Application ref: 6/2015/2340/HOUSE

**Proposed development at 8 Wilkins Green Lane, Hatfield AL10 9RT
Proposal: 2 storey extension, conservatory and modifications to roof**

Drawing Title
Proposed Elevations

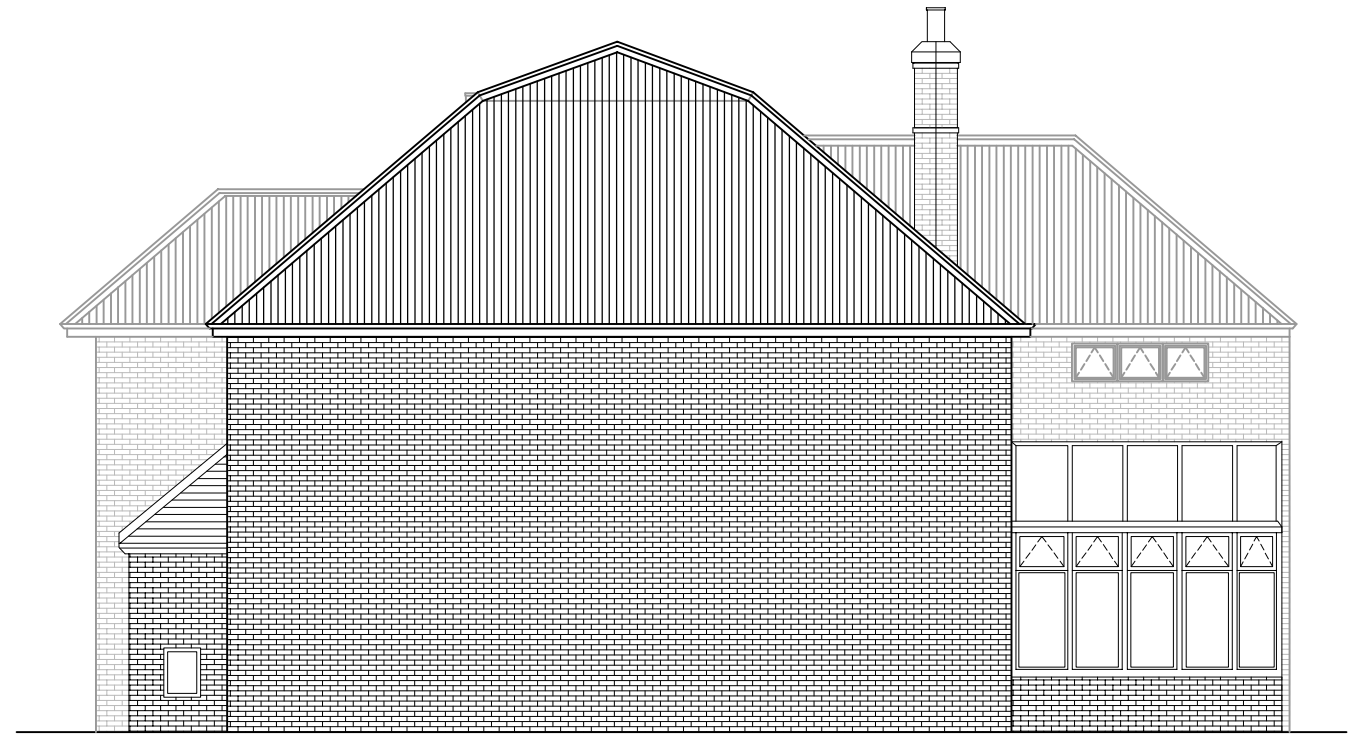
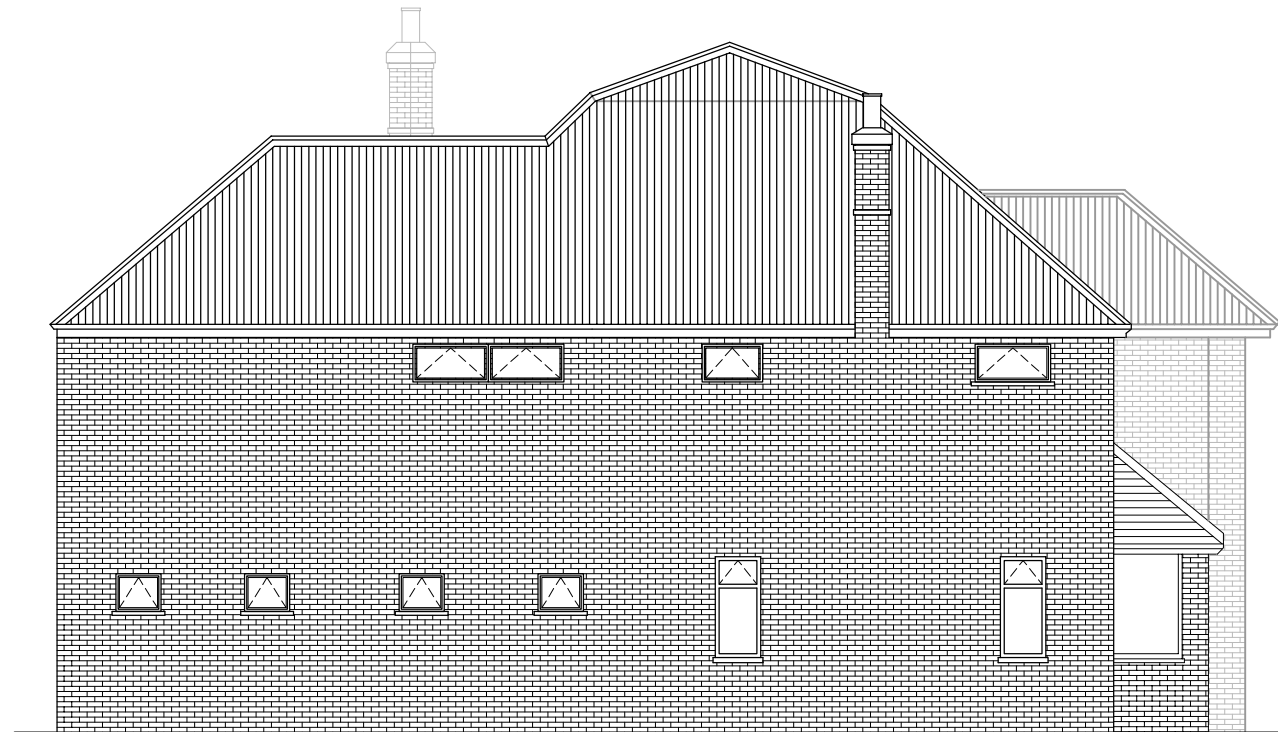
1. The proposed development will restrict light to the following rooms of our house:
 - (i) Our daughter's rear bedroom. The side window currently allows in light, but this will be very much reduced.
 - (ii) The middle downstairs reception currently used as a living room/TV room.
 - (iii) The downstairs shower room
 - (iv) Our kitchen although this to a lesser extent than the other three rooms, as the kitchen is set further back from the extensive outside wall of the proposed new development.

2. The proposed development will have an adverse affect on the visual amenity as follows:
 - (i) The outlook from our daughter's room's side window will be straight into a brick wall just a few feet away.

- (ii) The outlook from two windows in our son's bedroom will be towards the large brick exterior wall of the proposed development, albeit further back than from our daughter's bedroom.
- (iii) The outlook from our kitchen will be straight onto the large exterior brick wall of the proposed new development. Some of the wall may be obscured by the tall hedge but there will still be a considerable impact on the visual amenity.

We would have no objection if the planning application were amended to be a single storey extension and conservatory as this would not adversely affect our property in the same way as the present application does.
